Morecambe Offshore Windfarm Generation Assets

The following constitutes Natural England's formal statutory response for Examination Deadline 2.

Appendix B4 to Natural England's Deadline 2 Submission

**Natural England's comments on [REP1-080] 9.22 Offshore Ornithology Technical Note
1_EIA**

Plate 3.1 Exclusion fence specification (Source: RSPB)

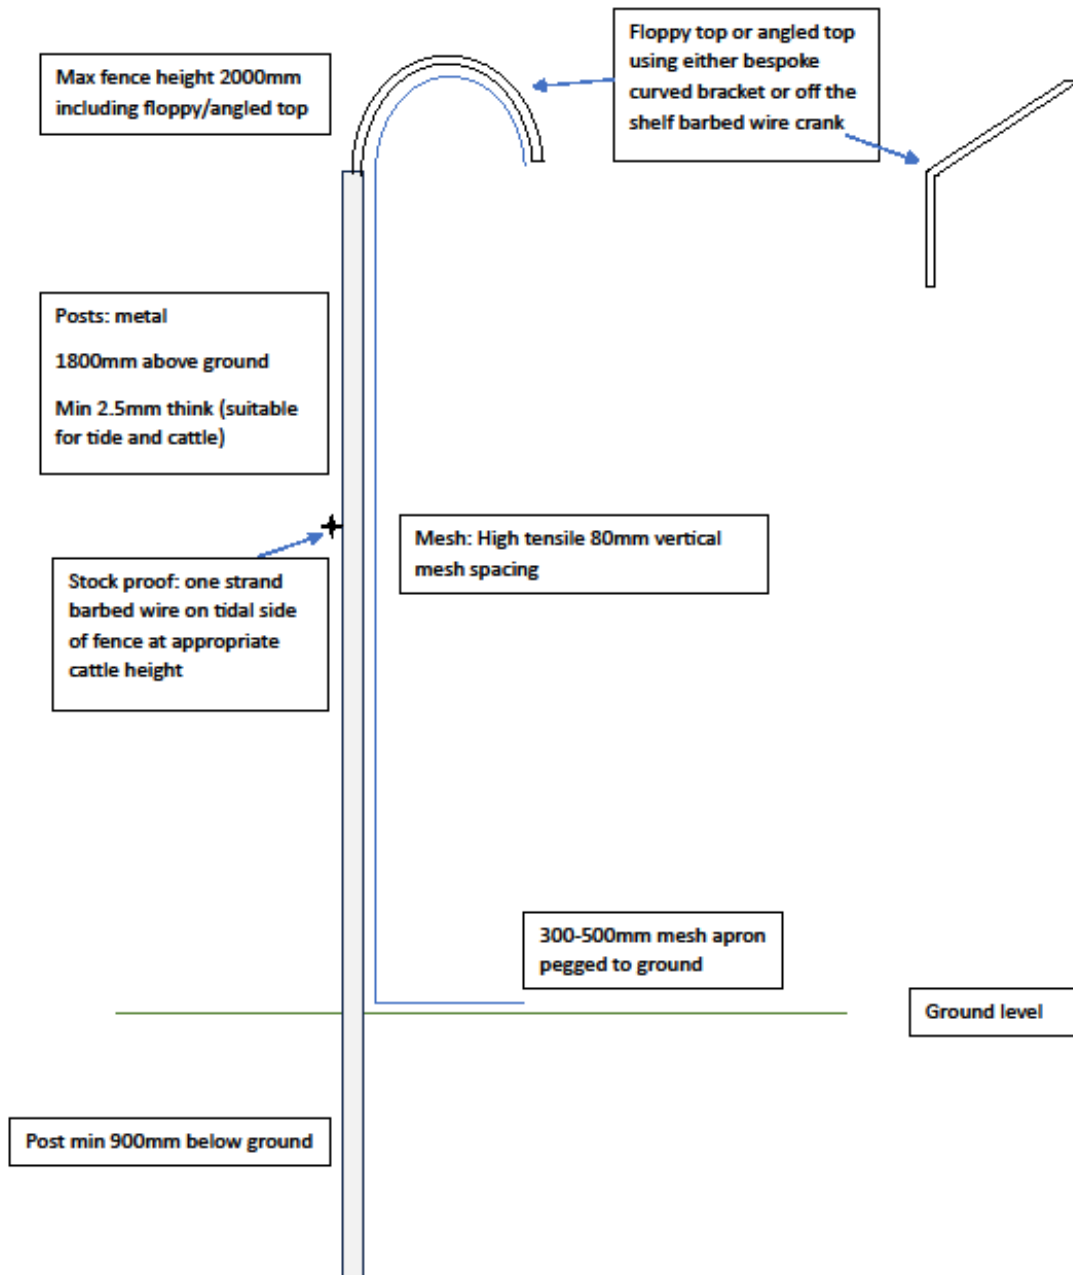
NE Ref	Section	Key Concern and/or Update	Natural England's Advice to Resolve Issue
1	3.1.3; 23/25	<p>We welcome the reported progress made in relation to the Banks March predator-exclusion fence in the Ribble and Alt Estuaries SPA. We appreciate that this proposed project is still in the planning stages and agree that the area quoted, at approximately 1750 Ha could theoretically provide more than enough habitat to satisfy any compensation requirement (if deemed necessary) if a sufficiently large area is suitable as lesser black-backed gull nesting habitat.</p>	<p>We understand that a draft feasibility study has been completed by the RSPB for the Banks Marsh mega fence. however, it has not yet been made available in Examination documents. We therefore make the following comments on the Banks Marsh option whilst acknowledging that more information may be contained in the study report.</p> <p>We are aware that the Applicant would be making a financial contribution towards the construction and maintenance of the enclosure, rather than managing Banks Marsh itself. However, it is not yet clear how much of the 1750 Ha quoted is considered currently suitable habitat for nesting gulls, how much has previously been used by gulls (noting an apparent complete colony collapse since 2022), nor how much will be assigned to the without-prejudice compensation project.</p> <p>In addition, we are aware that some of this area is not protected by a new embankment, is consequently liable to flooding at certain times (e.g. high spring tides), and this has previously resulted in reduced lesser black-backed gull breeding success. We understand that climate-related higher tides (amongst other things) cannot be ruled out as a contributory factor in the recent colony collapse.</p> <p>As such, we consider it would be useful if an indicative location and figure for the extent of land suitable for nesting gulls could be provided, including the area to be</p>

<p>monitored for the purposes of satisfying any compensation requirement (if deemed necessary).</p> <p>Some consideration of the future impacts of climate change on flooding extent and periodicity within the potential timescale of compensation (if required), i.e. approximately the next 40 years, which includes the period of construction plus the 35-year lifespan of Morecambe OWF would also be useful.</p>
2	26	<p>We note the reference to the success of predator-exclusion fence enclosures at Hesketh Out Marsh East and Hesketh West in 2021 and autumn 2022 which has resulted in 2022 and 2023 in “<i>over 40 pairs within the fenced area with productively reaching 1.55 chicks per pair in 2023</i>”. It is unclear what species this refers to.</p>	<p>We assume this refers specifically to lesser black-backed gull but please clarify the species involved.</p>
3	3.1.4; 30	<p>We welcome the progress being made with the proposed habitat management on Steep Holm Island.</p> <p>We are aware however that several attempts at visiting Steep Holm in summer and autumn 2024 were cancelled due to prevailing weather conditions restricting transit.</p>	<p>We recognise that the Applicant has no control over the weather and accept that there may be occasions when visits to Steep Holm are not possible.</p> <p>We would nevertheless reiterate the advice we provided in our response to the 4.11 Habitats Regulations Assessment Without Prejudice Derogation Case submitted at application, that, should this measure be adopted, opportunities for scrub clearance are maximised at an appropriate time of year (i.e. September to February), subject to landowner agreement, whenever they become available within this timeframe to mitigate the risk that these essential elements of the project cannot be undertaken. This is also the case for nest/productivity monitoring/colour ringing (May to July).</p>

5	48/49	<p>We note that a flood risk activity environmental permit application will need to be made to the Environment Agency for works on a floodplain for the Banks Marsh mega fence.</p>	<p>We understand that for the majority of its route, the mega fence will be replacing existing enclosure infrastructure (fences, gates etc.) and no issues have been raised during informal consultation of local Environment Agency staff.</p> <p>Nevertheless, we would encourage the Applicant to ensure the necessary permissions are pursued as soon as possible such that we can have confidence this proposal can be progressed if considered necessary.</p>
6	Appendix B	<p>We welcome consideration of the Health and Safety aspects of the proposed Steep Holm habitat management option and note that hazards have been identified and solutions either proposed or currently subject to further consideration (e.g., lack of hot running water for showers). Should this latter issue be unresolvable we accept that daily visits rather than stays over multiple nights may be necessary.</p>	<p>We recognise that the health and safety of all those involved in this project is of the utmost importance and overrides all other considerations.</p>
